Rezoning Transportation Analysis

Petition Number: 2021-078

Date	Description
08-02-2021	First Review (DBS)

The petition is located adjacent to Ridge Road, a City-maintained major thoroughfare west of Cooper's Ridge Lane, a City-maintained local street. The petition is located in the Northeast Wedge outside Route 4. Applicable area plans include the Prosperity Hucks Area Plan.

REZONING PLAN
RZ.01

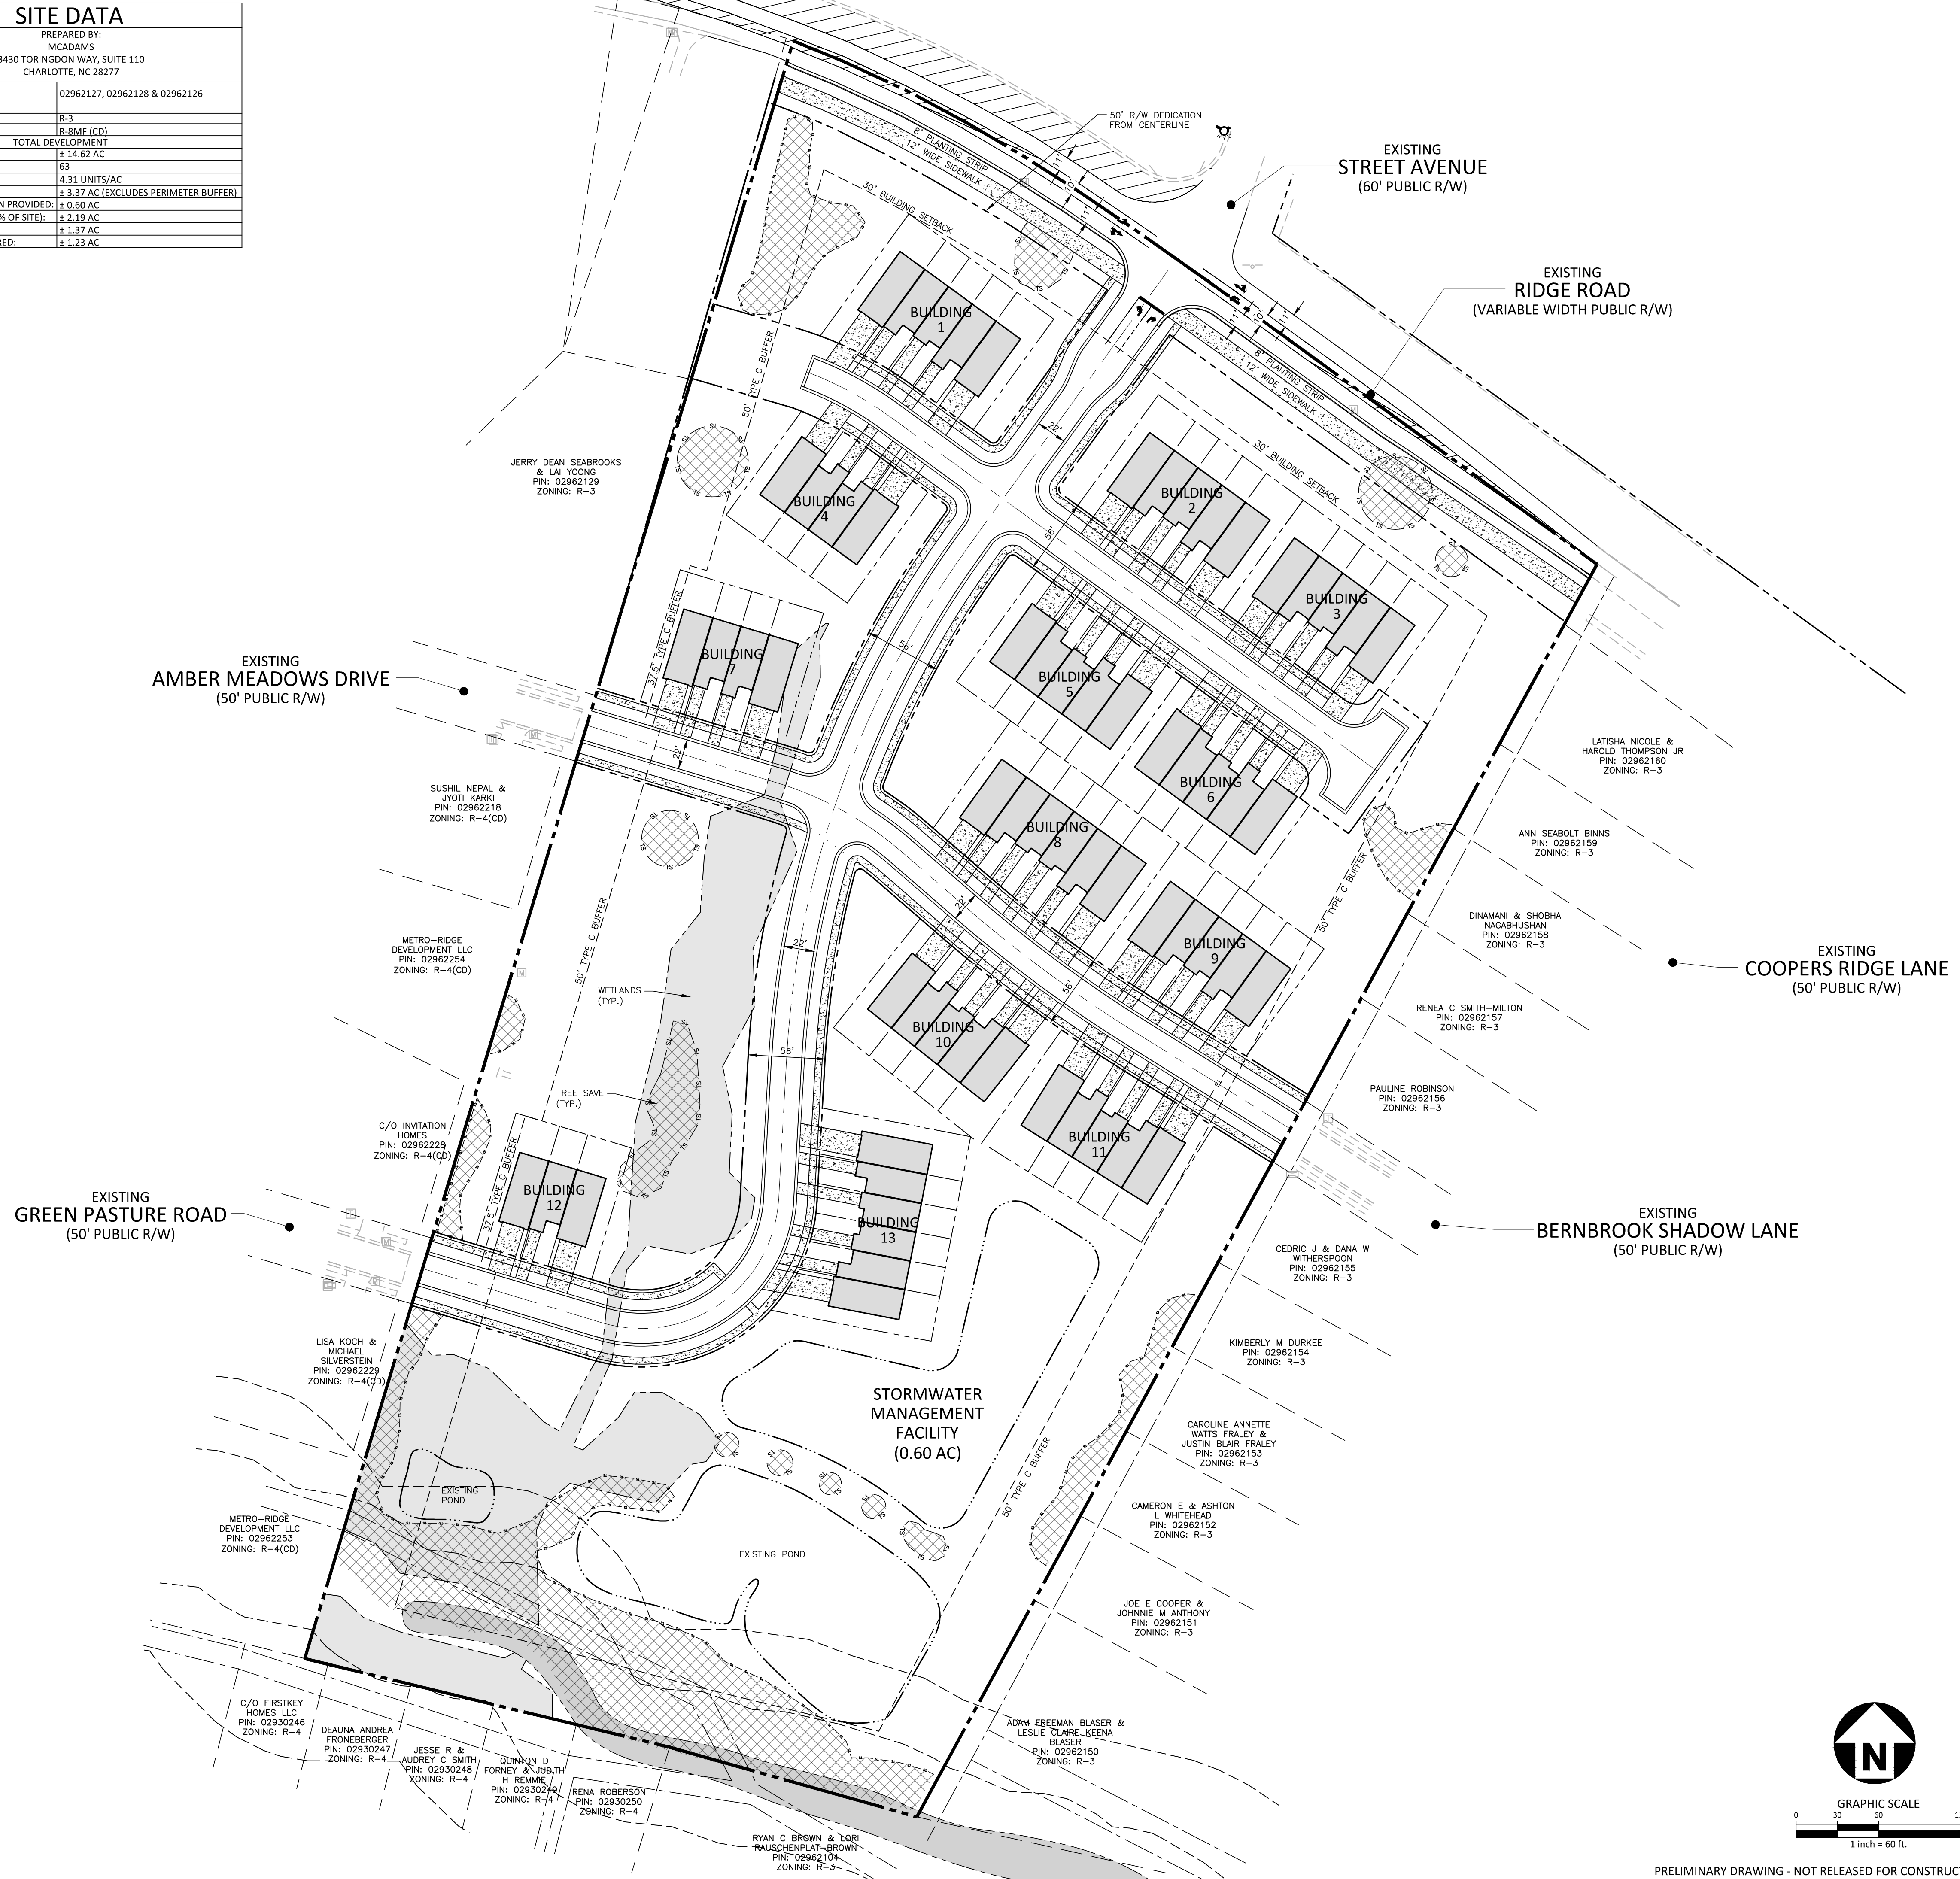
Ridge Road: Back of curb and gutter will be established at 30-feet from existing Ridge Road centerline. Label and dimension the curb and gutter from the centerline.

3. Revise site plan and conditional note(s) to commit to dedicate 52-foot right-of-way from the road centerline. The site plan shall label and dimension the right-of-way from the road centerline.

4. The site plan shall label and dimension the multi-use path from the centerline of Ridge Road. Revise site plan to include these dimensions and labels.

5. Add note to site plan committing to coordinating with CDOT during permitting to determine the appropriate striping along Ridge Road.
6. Revise site plan and conditional note(s) to commit to connecting new streets to three adjacent stub streets.

7. Revise site plan to include two curb ramps at each corner of each public street intersection.
8. Revise site plan to reflect Ridge Road left turn lane widths of 11-feet.

9. Revise site plan to dimension lane widths at the development approach to Ridge Road. Appropriate pavement marking will be coordinated with CDOT during permitting.

10. Revise site plan to add labels to all proposed public streets and the appropriate CLDSM standard to be used.
11. A site plan note(s) specifying dedication and fee simple conveyance of all rights-of-way to the City before the site's first building certificate of occupancy is issued is needed. CDOT requests rights-of-way set at 2' behind back of sidewalk where feasible.
